Appeal Decision

Appeal Ref: APP/R5510/W/21/3277296

84 East Road, West Drayton UB7 9HA

- The appeal is made under section 78 of the Town and Country Planning Act 1990 against a refusal to grant planning permission.
 - The appeal is made by Mr & Mrs Agrawal against the decision of the Council of the London Borough of Hillingdon.
 - The application Ref 31005/APP/2020/3975, dated 1 December 2020, was refused by notice dated 27 May 2021.
 - The development proposed is described as, "New Dwelling House".
-

SITE PLAN

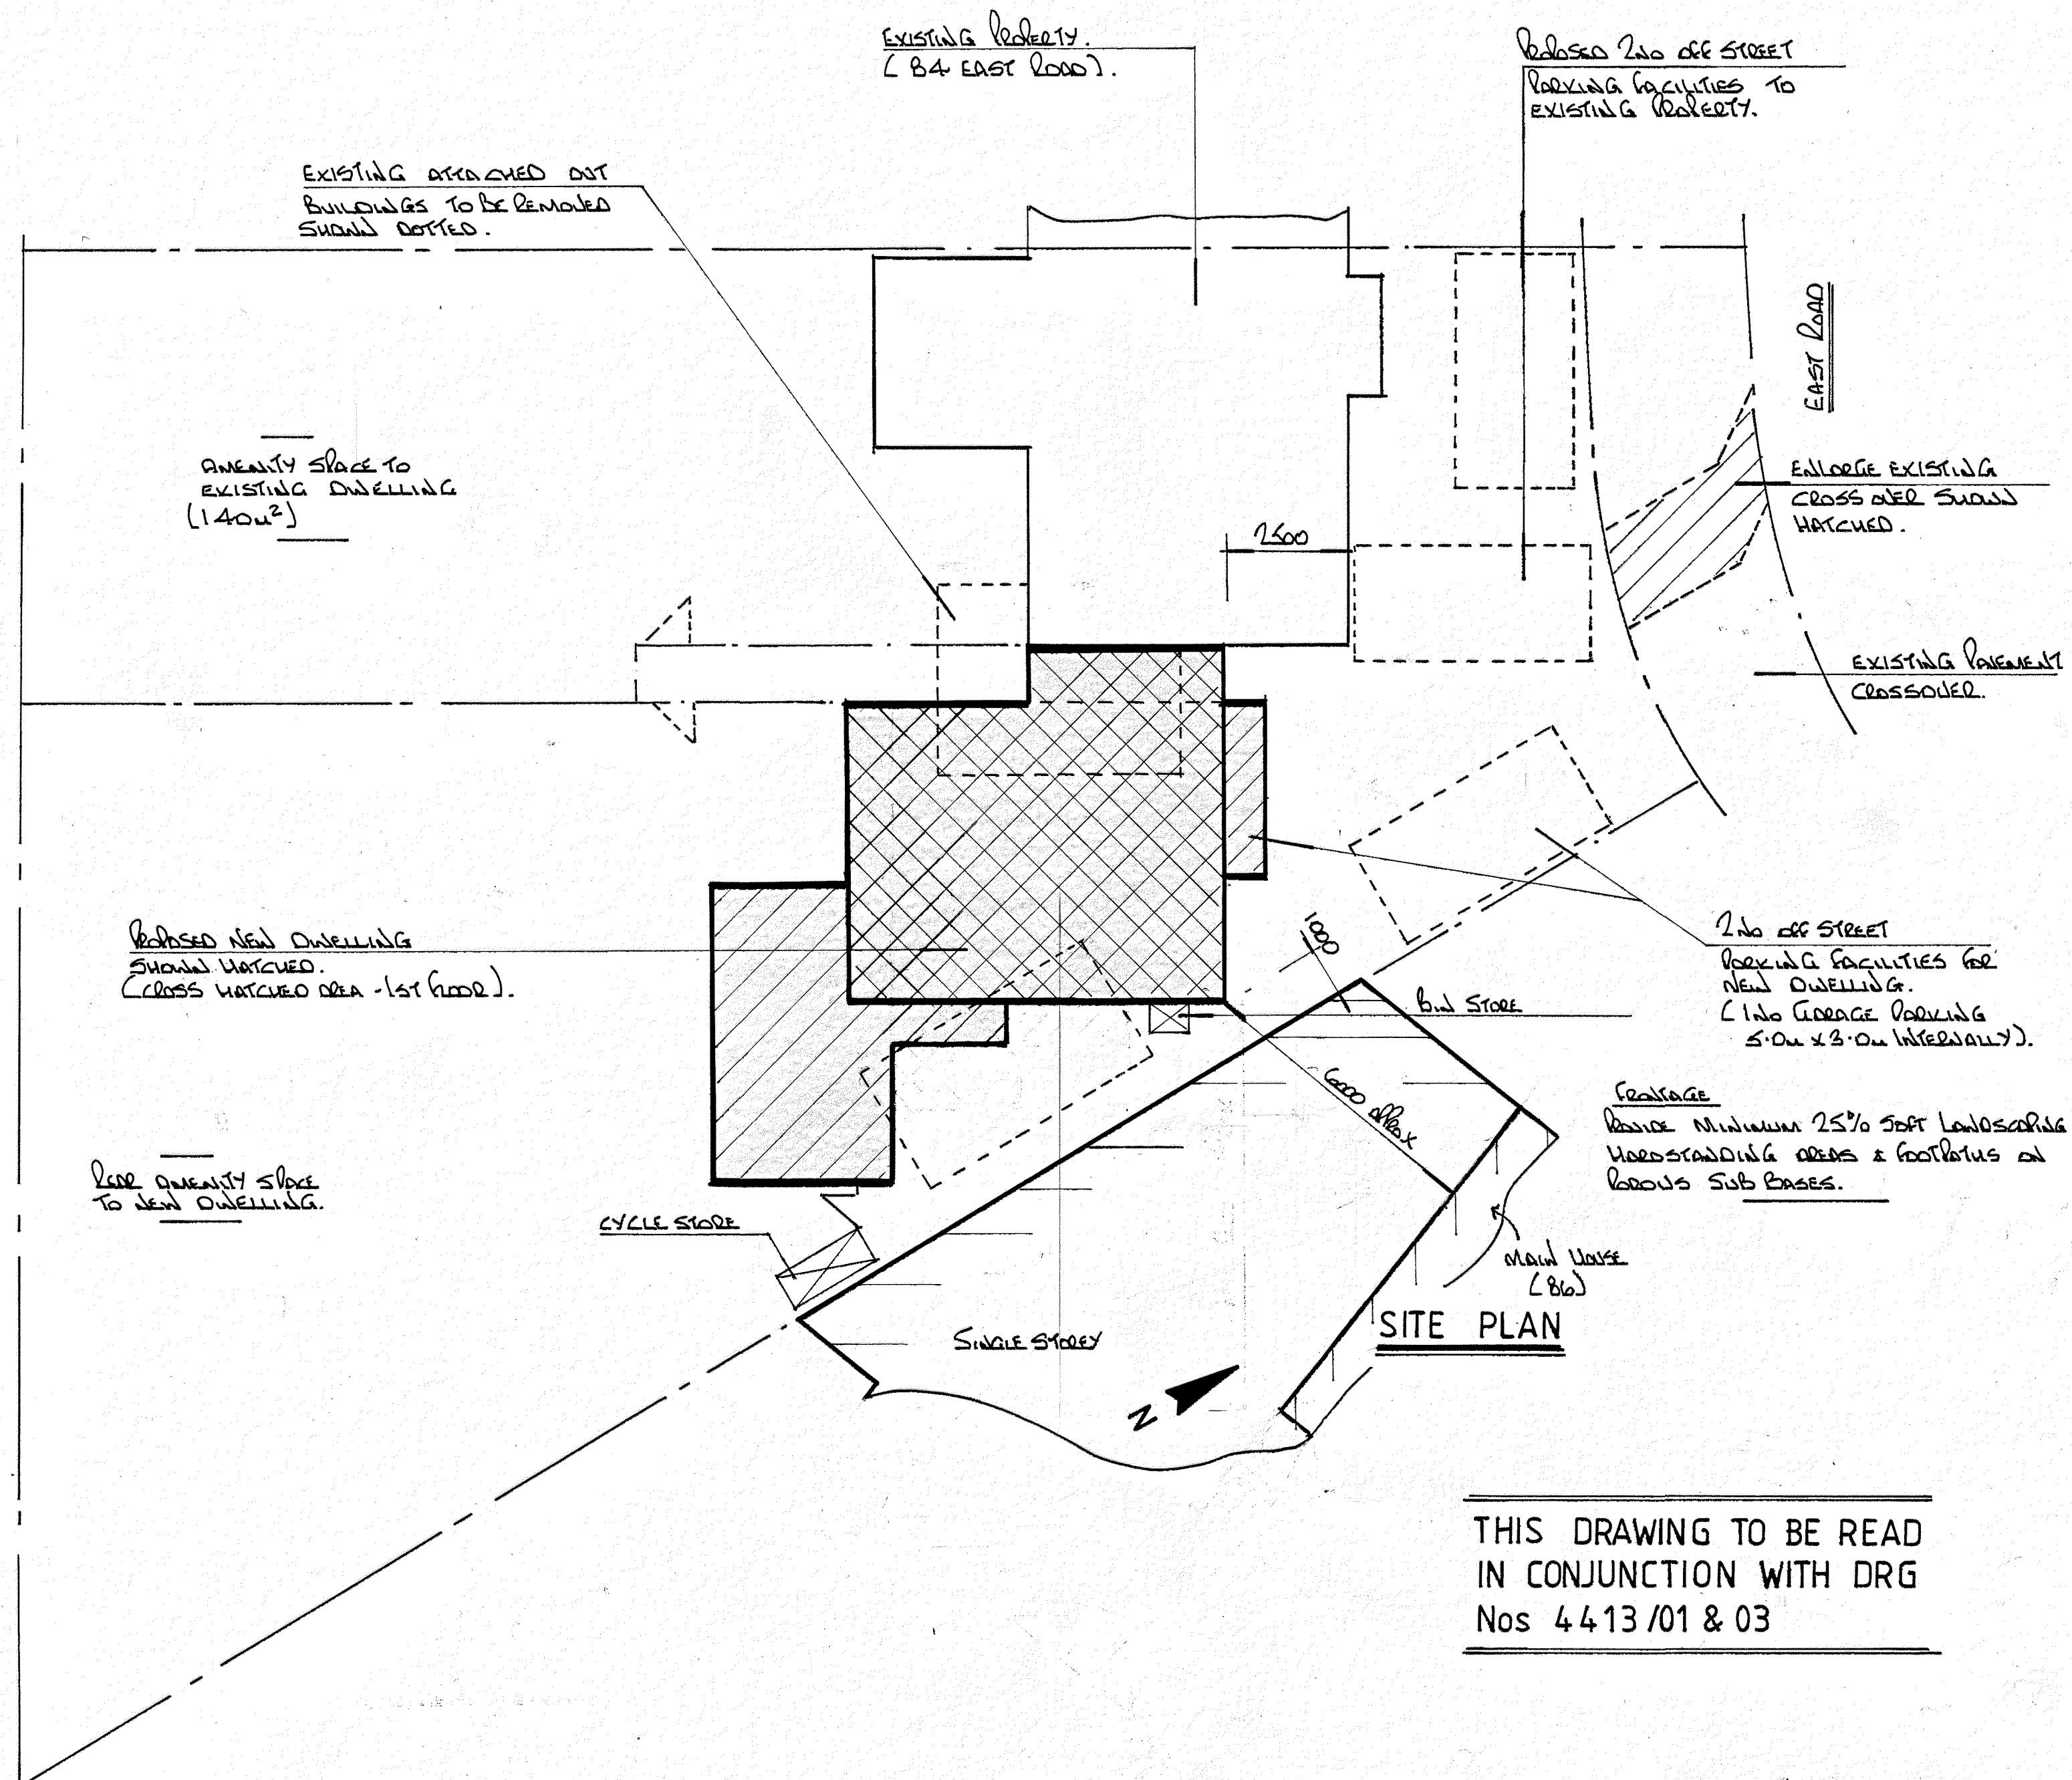
9. The proposal seeks to provide 2 off-street parking spaces for No 84 and 2 off-street parking spaces for the proposed new dwelling (one within the proposed

garage). The first space serving No 84 would be parallel to the road and the second space would be at right angles to the road. This would mean that the first space would not be available for access if a vehicle were to be parked in the second space. The Local Highway Authority has also confirmed that they would not support a dropped kerb for the proposal, for a number of reasons, including that parallel parking to the carriageway should not be permitted. Consequently, on the basis of the evidence before me I am not convinced that the proposal would provide 4 useable spaces.
